Application No. H06/1232/00

New Access +  
Pipe Dyke

**Re:- Access to Sunrise, Raven's Bank, Sutton St James**

**Pipe existing section of dyke and construct new access, Sunrise, Ravens Bank,  
Sutton St James – Mr A Drewery.**

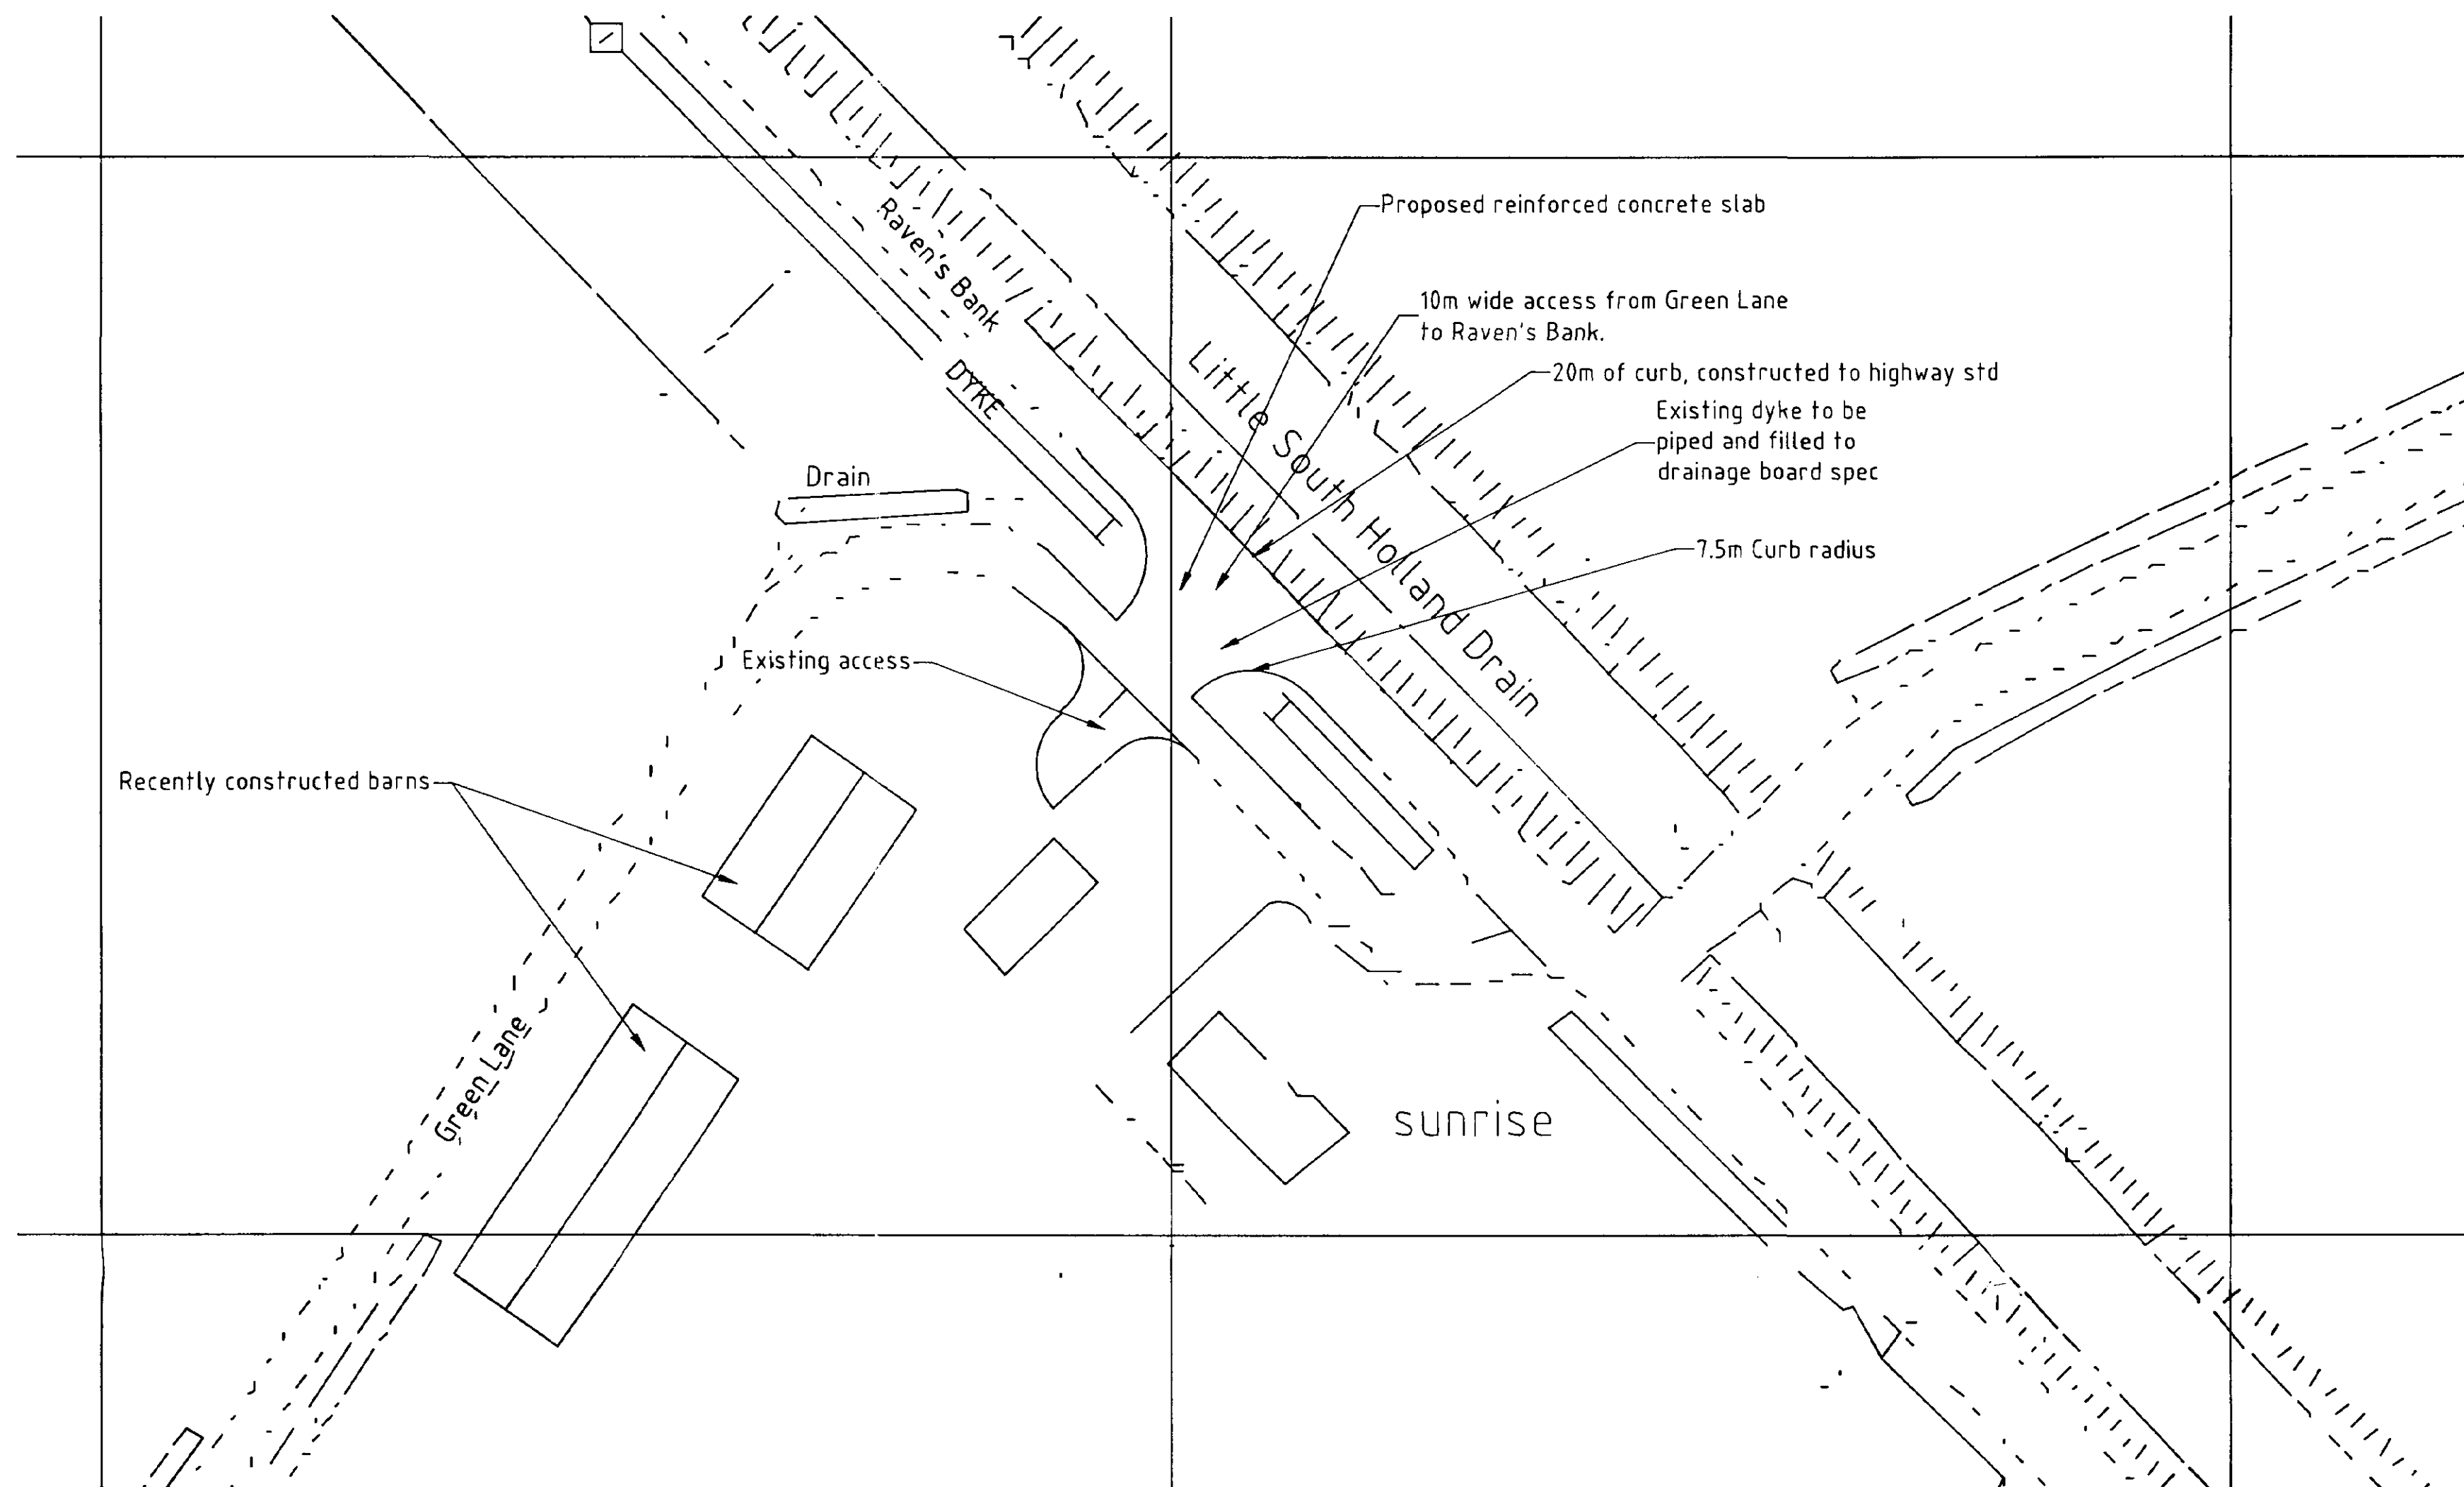
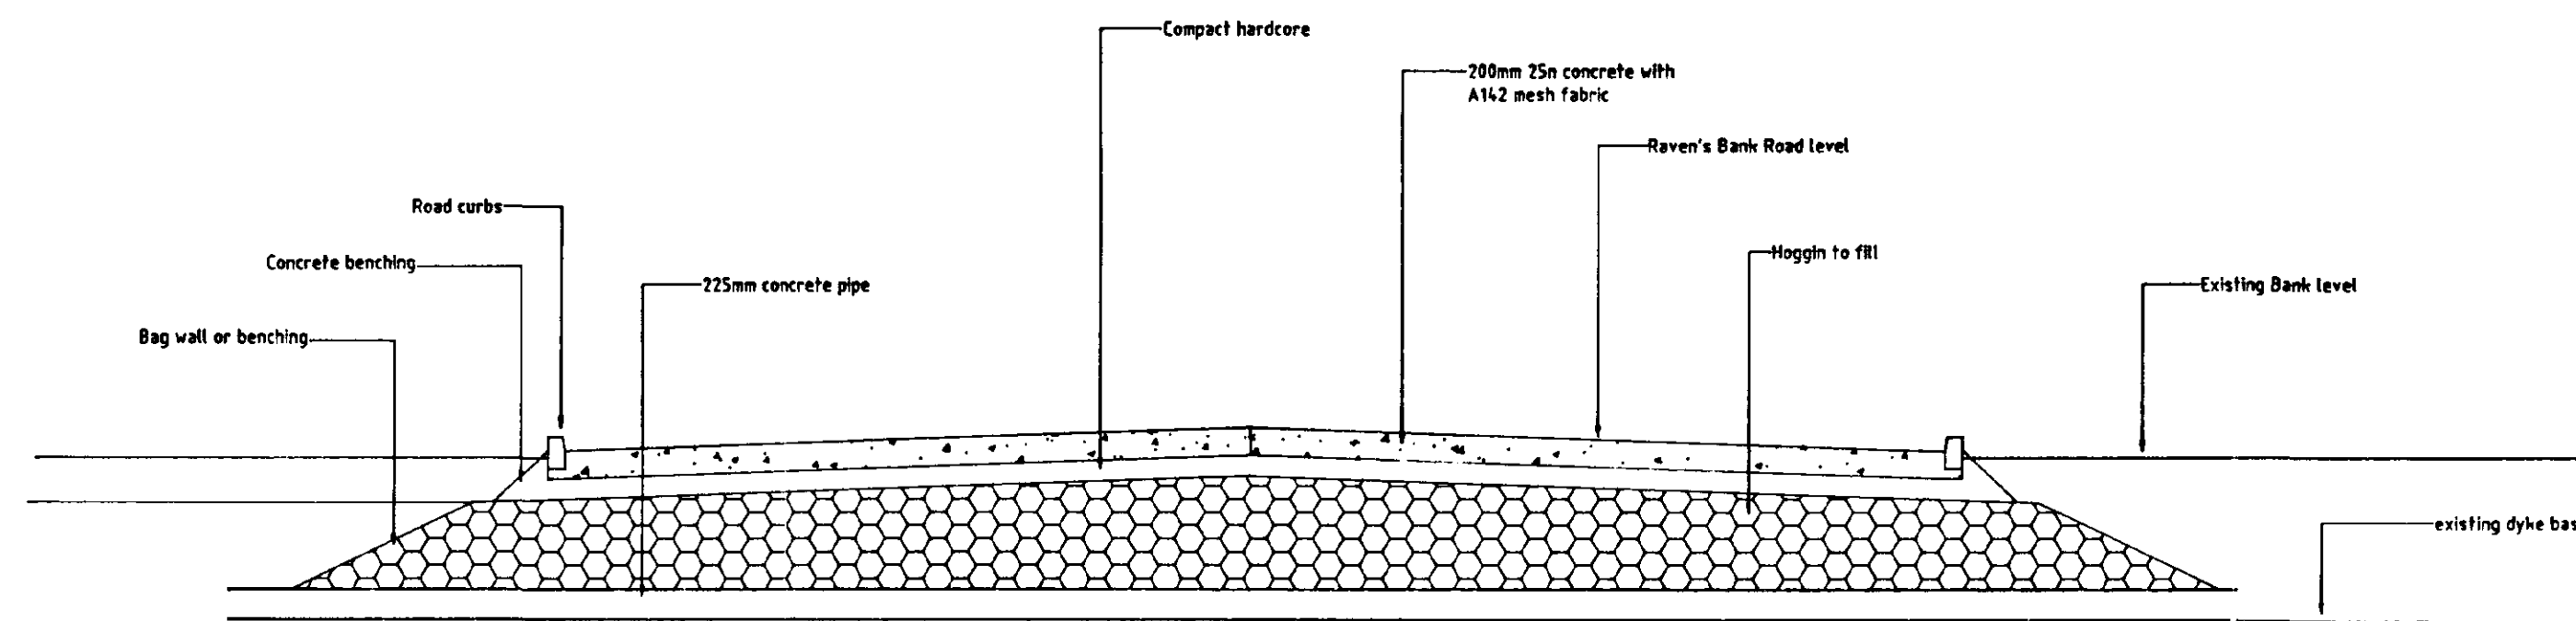
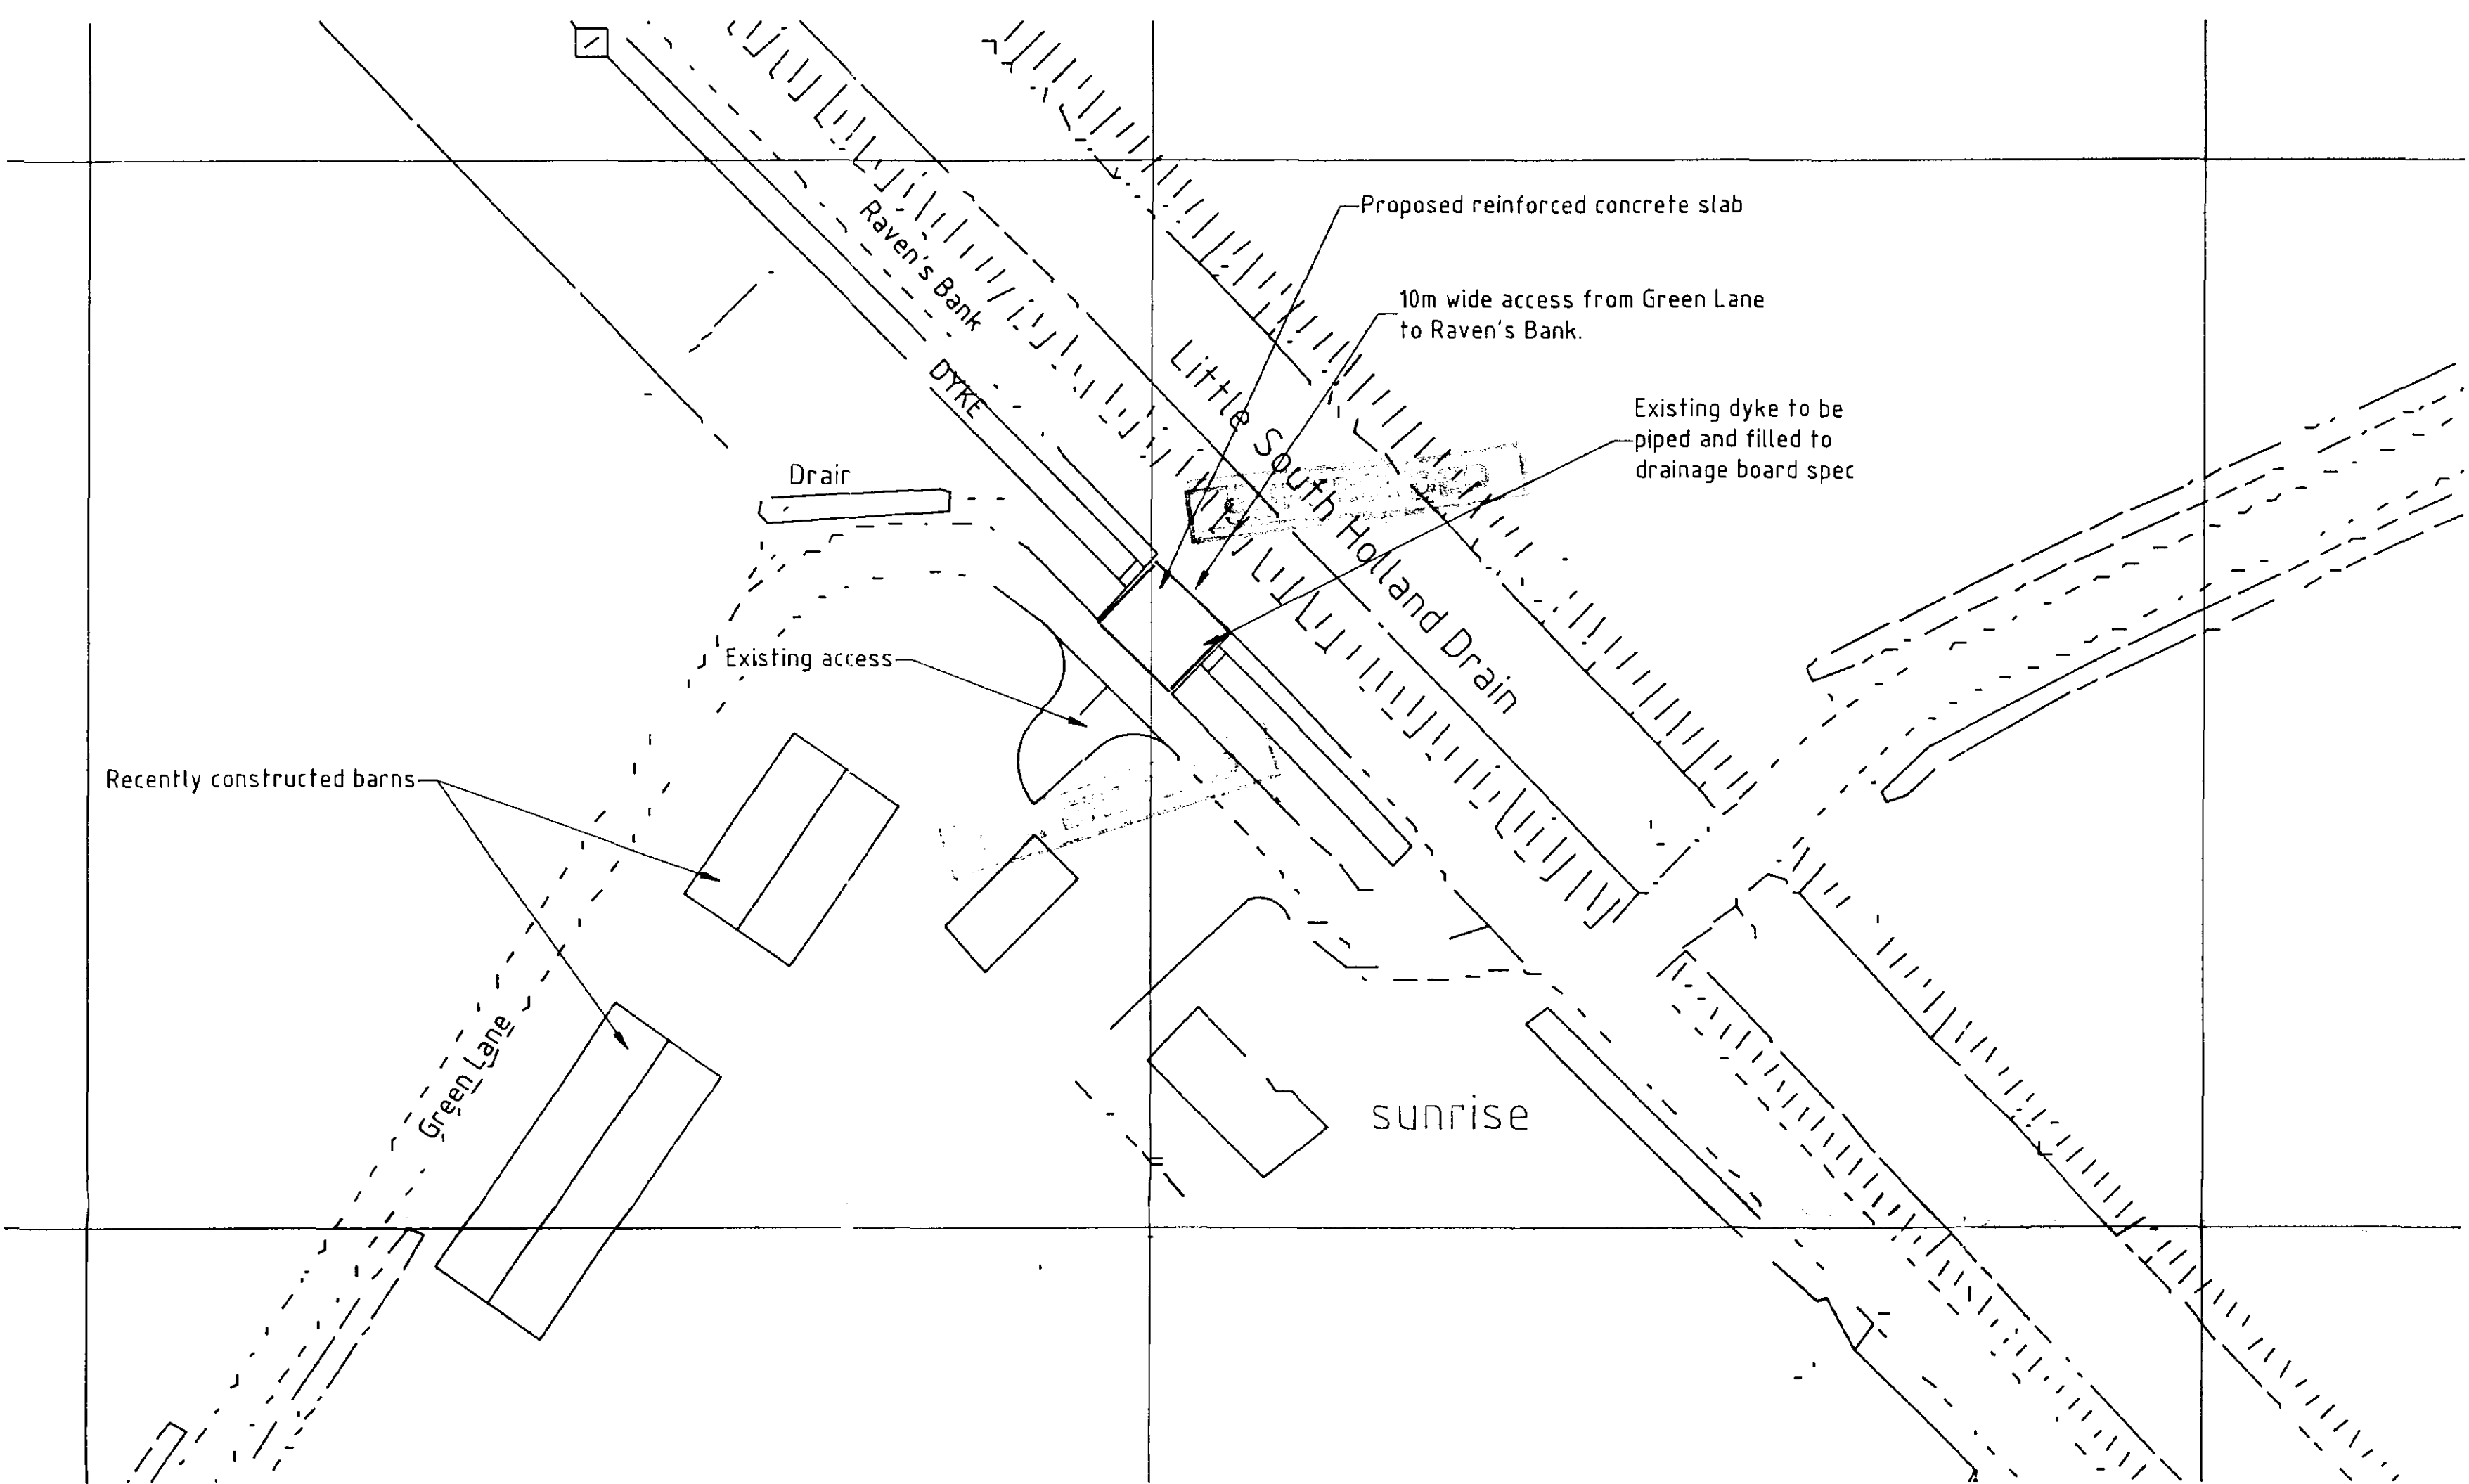
The County Highways Office have now made formal representations and consider that the new access should be of a higher standard (see enclosed drawing). It should include the provision of 7.5 metre radii (curbed). The carriageway edge opposite the permitted access should also be curbed for a distance of 20 metres (i.e. 10 metres in both directions from the projected centre line of the access). Such work should include adequate drainage provision.

Regarding the surface this should obviously be suitably hardened and further details will be required of its construction.

Finally, will the access be reserved purely for use by vehicles visiting the site or will it also be available for use by any vehicle using Green Lane. If it is the former how will this be achieved?

Thank you for your letter of 31 January 01 concerning the above property, I now enclose revised drawings showing the curbed 7.5m radius, section detail showing proposed construction and details of curbing to opposite site of Raven's Bank.

My client is happy to consider any option for the limiting of traffic across the access, I suggest two signs at the access junction, 'no right turn' from access road to Green Lane and 'no left turn' from Green Lane to access road, alternatively a lift up barrier across the access road could also restrict unauthorised use.
